CITY OF ALBUQUERQUE

Re: Central Avenue and 98th Street Coffee Shop
Traffic Impact Study, HT#K09D054
Report dated May 2022
Engineer's Stamp -----
Via email jkruse@lee-eng.com

The subject Traffic Impact Study draft received on May 15, 2023, has been reviewed by the City of Albuquerque Planning Development Transportation Section. The City has the following comments to be addressed.

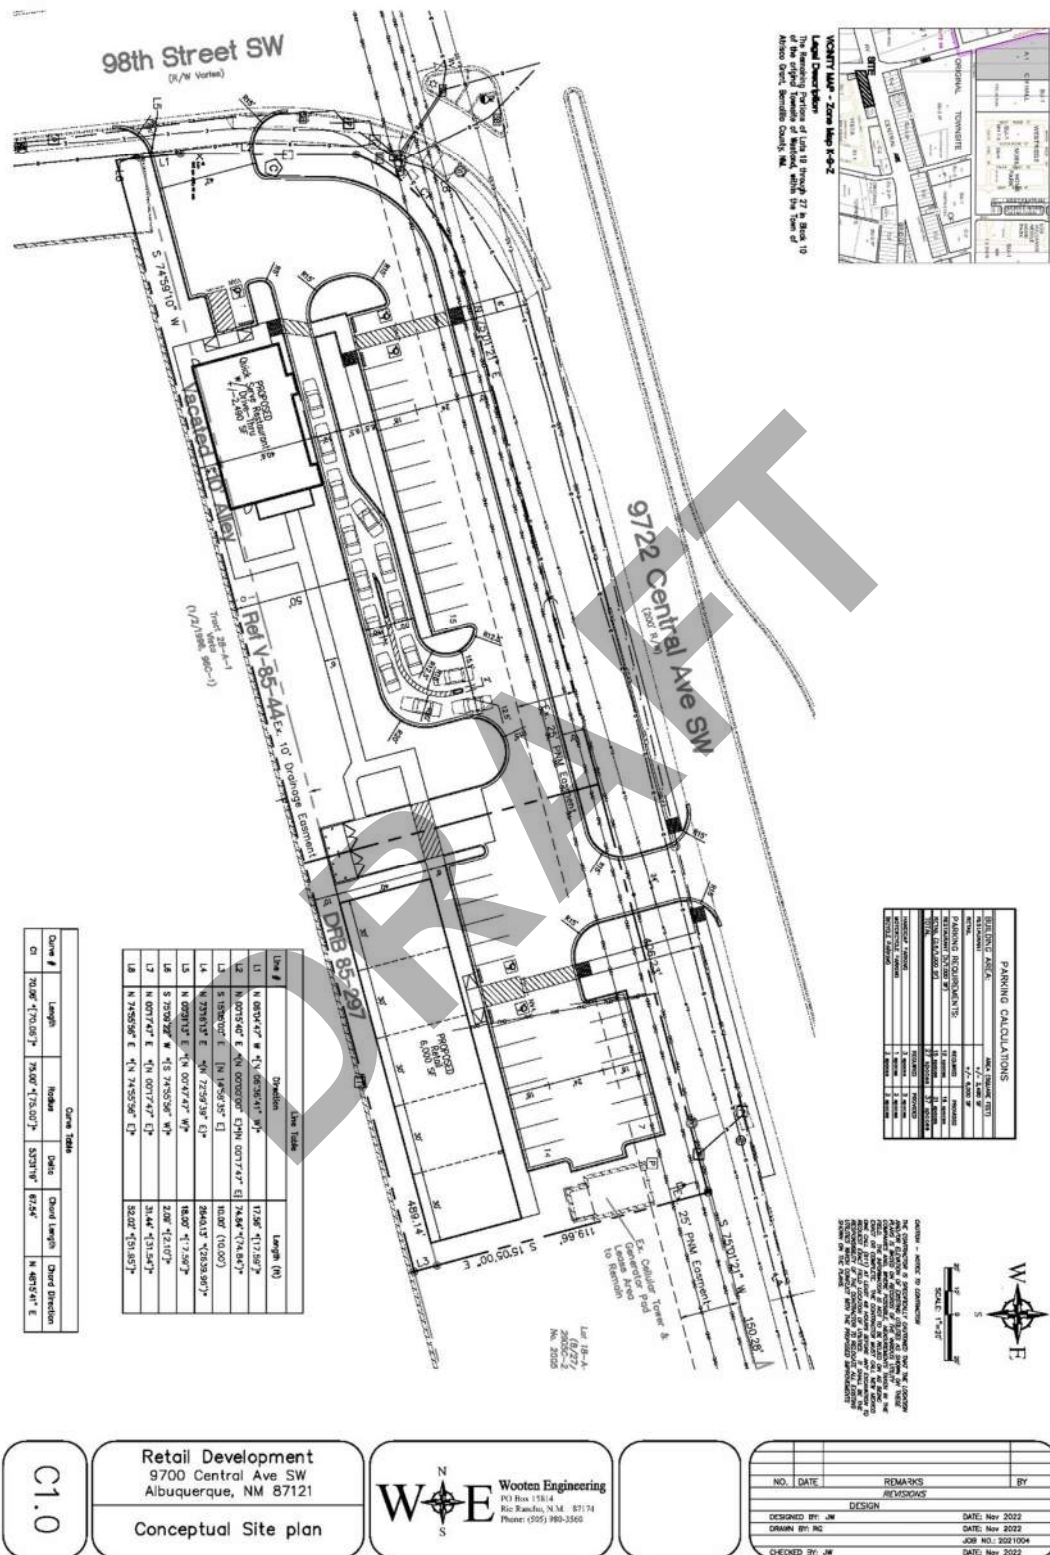
1. Driveway #1 on 98th St. is too close to Central Ave. The DPM requires 300 feet on an approach to a Principal Arterial on an Arterial. The partial access of right-in/right-out will not be allowed.

- Reevaluate the TIS with:
 - Driveway #1 as a right-out only and
 - without Driveway #1
2. Investigate the possibility of constructing an eastbound left-turn lane on Central Ave. at Westside Rd. The median has sufficient width for a turn lane but is landscaped.
